# KITTITAS COUNTY FIRE MARSHAL'S OFFICE

July 13, 2011

Re: Olexsy (BL-11-00011)

**OLEXY PROPERTY**

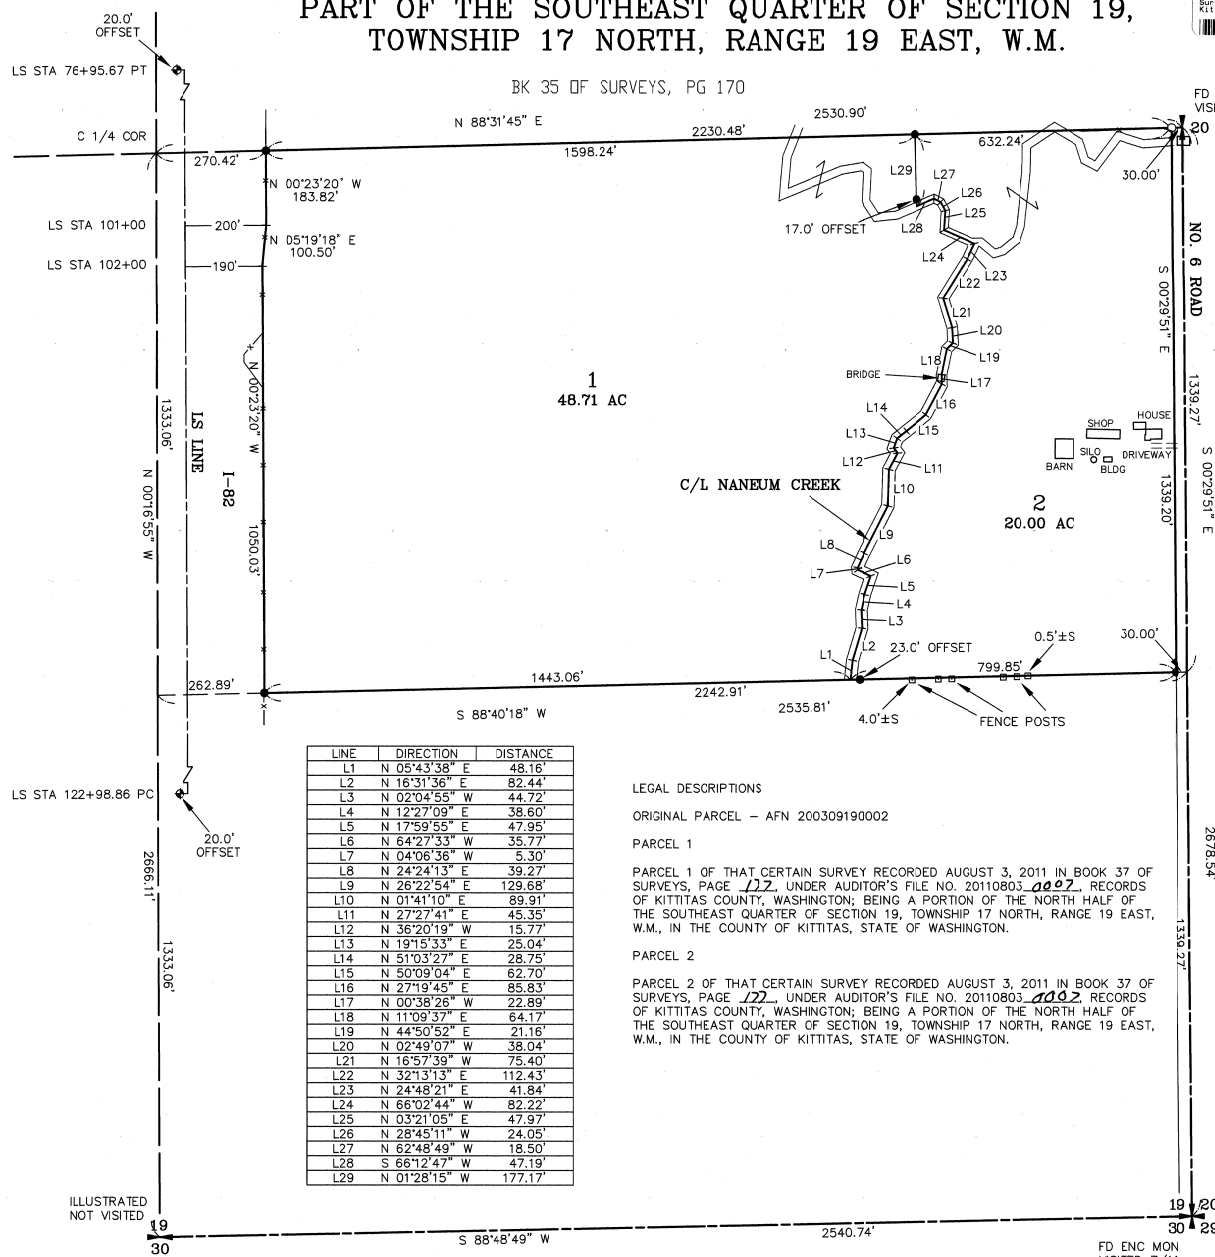
- Ensure that boundary line adjustments do not infringe upon existing structures, to include propane tanks, etc.
- Creation of any additional roads or access must comply with the International Fire Code.
- All future development must comply with the International Fire Code.
